CITY OF ALBUQUERQUE

November 25, 2013

**Re: Guttman Residence, Lot 22 Rancho Guadalupe Subdivision
1626 Rancho Guadalupe Trail
Grading and Drainage Plan
Engineer's Stamp Date 08/23/2013 (F13/D002B)**

GRADING AND DRAINAGE PLAN

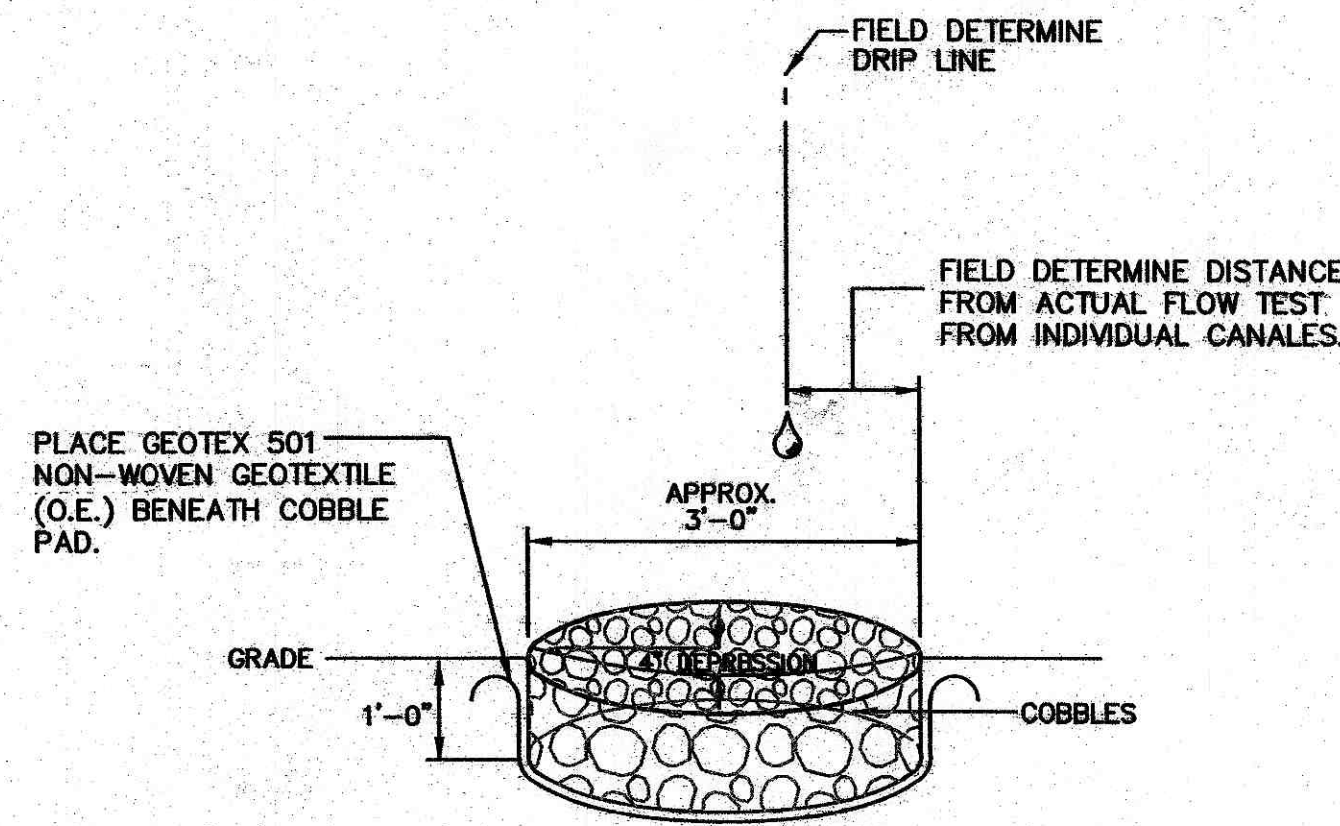
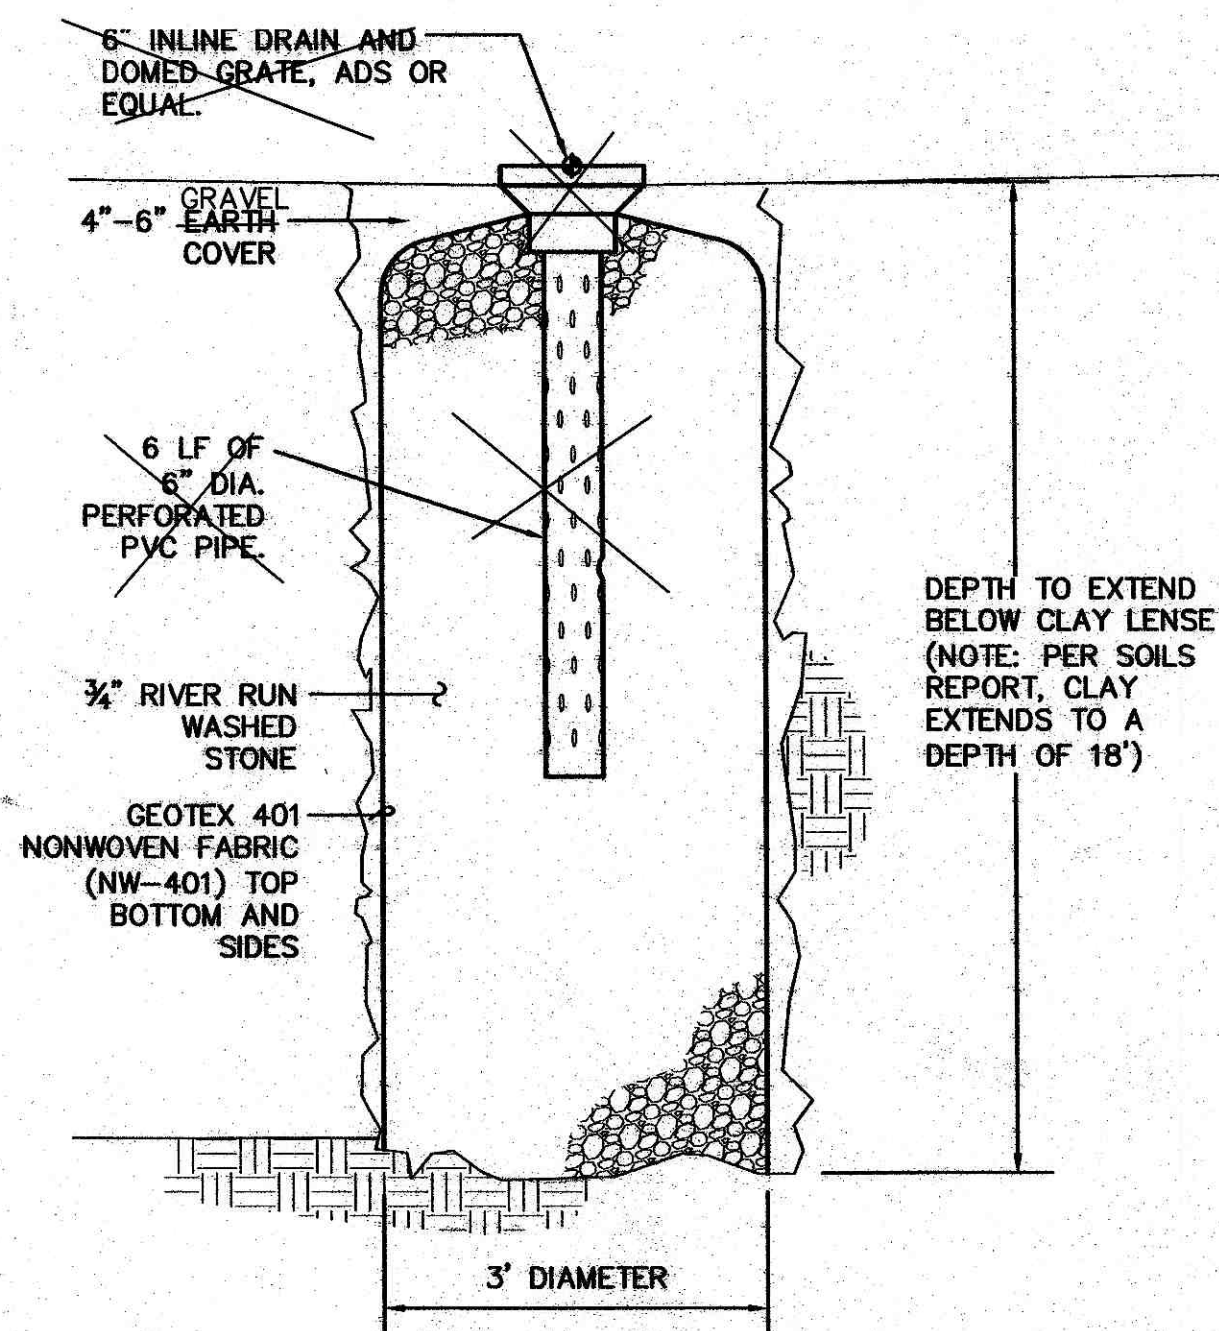
- Neither existing topography nor existing spot elevations are shown on the plan.
- A City of Albuquerque Benchmark with NAVD 88 elevation is shown on the plan, but the proposed elevations are the same as the original grading plan which an old Benchmark elevation.

- Provide pond volume calculations for the proposed ponds.
- Provide proposed and existing elevation at the south end of the property. What kind of slope is being proposed for the slope grade transition area?

- Provide additional spot elevations around the pool area to assure positive drainage.
- Clearly show the property line, and label all the existing easements on site. Is there a wall being extended to the northerly property line across the existing drainage easement?

- The as-built grading and drainage plan for Rancho Guadalupe prepared by Terrence W. O'Brien (NMLS#12801) in 1999 provides five as-built spot elevations for this property. Pad grade = 71.79 (design grade = 71.85) and property corner grades ranging from 70.8 to 71.2 (design grade = 70.85 typical). A copy of that portion of the as-built is attached with this letter and the spots have been added to the plan.

- The benchmark has been corrected to the same benchmark as the original design.
- Pond volume calculations have been added to the plan.
- Per the original overall grading plan, the south property transition slope varies. For this lot, the existing grade on the adjacent property is $74.0 \pm$. The grade transition of 2.3' over 7' is currently achieved with a graded slope. This will have no impact on the required pond volumes or locations. Spot elevations have been added reflecting the grade transition.

- The future pool will not be designed / constructed with this plan. Spot elevations have been added to indicate positive drainage away. Ultimately, the pool and surrounding deck elevation will be established by others based on owner preference. We have added spot elevations to the plan indicating that the pool be constructed at 72.1.

- Property line has been clarified and all easements have been labeled. The existing and proposed perimeter walls have been updated (see existing site photos on page 2): No walls will be added other than the west side yard walls shown and the proposed plan.

SECTION 'A'

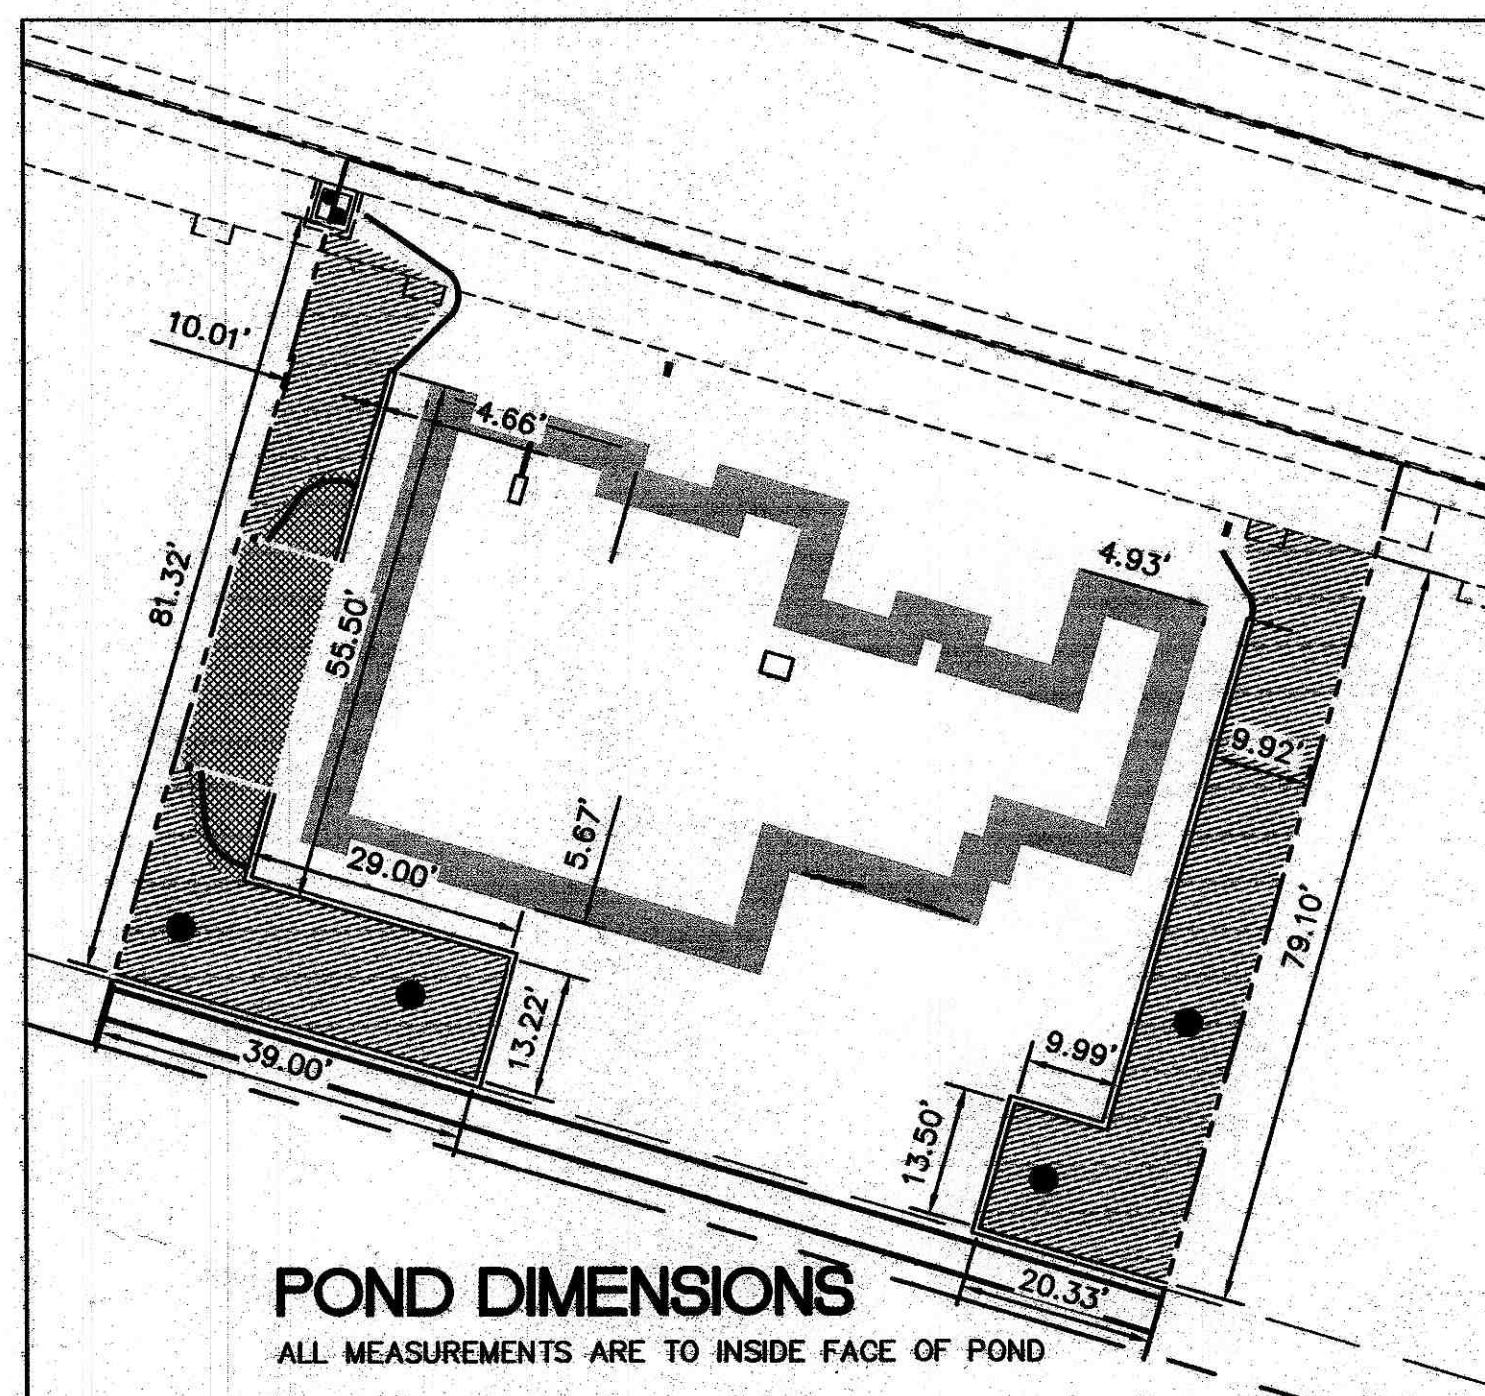
- Based on the overall grading and drainage plan, the low points between the pads are at the property lines to the east and to the west. Are these areas considered to be common drainage areas/easements? Will the proposed pond walls shown on Section A stop the runoff from the adjacent properties?

- Based on the overall grading and drainage plan, this lot and the adjacent lots each have pad grades of 71.85 sloping down 1' to 70.85 at the side ponding areas. The flat-land grading solution uses the overall storage volume required divided amongst the various lots to achieve a 'typical' storage volume per lot. The proposed pond walls shown on this plan are provided to achieve the necessary volume but will not prevent equalization between properties. We have added additional notes to Section 'A' to clarify.
